**Re: SSD-10448 – Aspect Industrial Estate**

This submission is in response to SSD-10448 which includes estate roads, Mamre Road intersection works, realignment of the existing creek, bulk earthworks and the construction and operation of Mirvac's Warehouse 1 and Warehouse 3. GPT's Mamre Road Site adjoins the Northern and Eastern Boundary and is therefore a key stakeholder of SSD-10448.

GPT have reviewed the exhibited documents of SSD Application and the *Mamre Road Precinct Draft Development Control Plan (November 2020)*. GPT objects to the proposed Staging of the Access Roads and elements of the E2 for the following reasons.

SSDA MOD 2 ESTATE WORKS STAGING PLAN

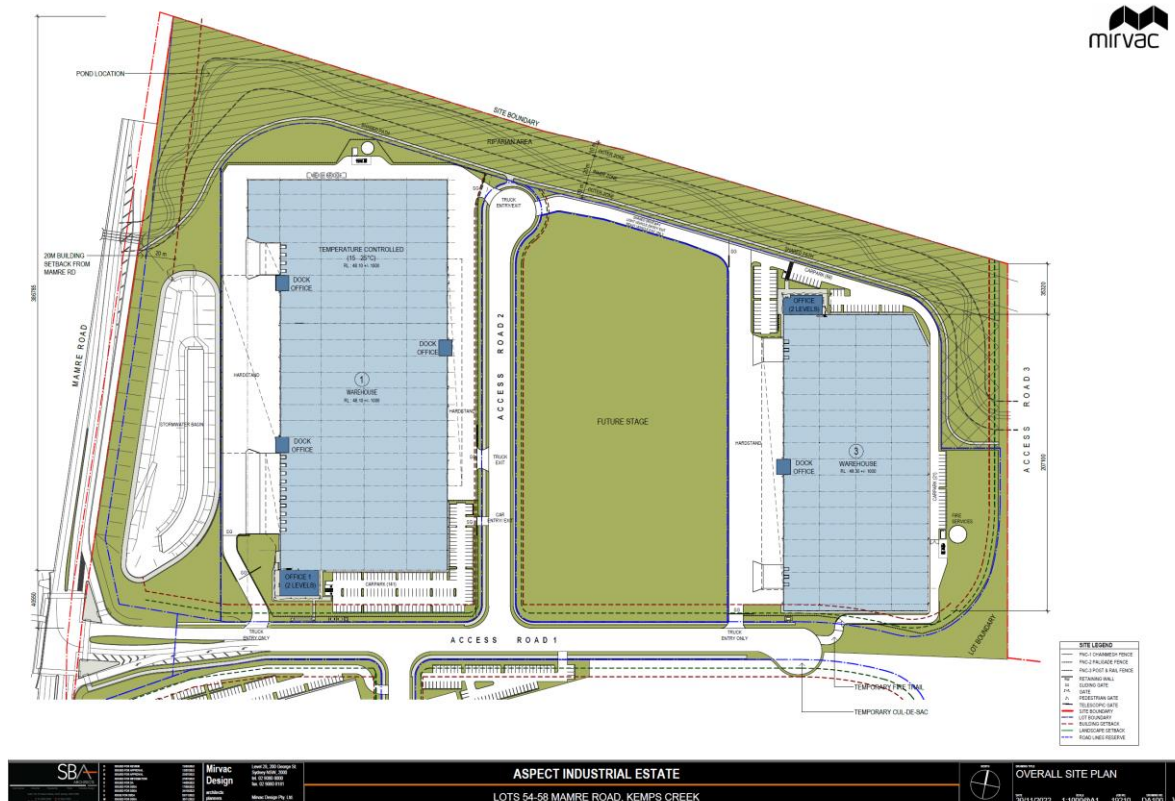
Access Road 1 as depicted in SSDA-10448 represents a High Order Road that forms part of the Mamre Road Precinct Road Network. SSDA-10448 only allows for the construction of a portion of Access Road 1 with a temporary cul-de-sac restricting access to adjoining properties and the continuation of the Precinct Road Network.

The road corridor provide critical infrastructure for the precinct. The partial construction of Access Road 1 impedes access to the required services and infrastructure for adjoining properties.

GPT request that Access Road 1 is extended to the Eastern Boundary as highlighted in Red in *Figure 1*. GPT will also comply by extending the access road to its northern boundary as part of SSD-10272349.

It is also requested that Access Road 1 is completed to the Eastern Boundary prior to the construction of Warehouse 1 and 3 to ensure the Mamre Road Precinct Road Network can be delivered in a timely manner.
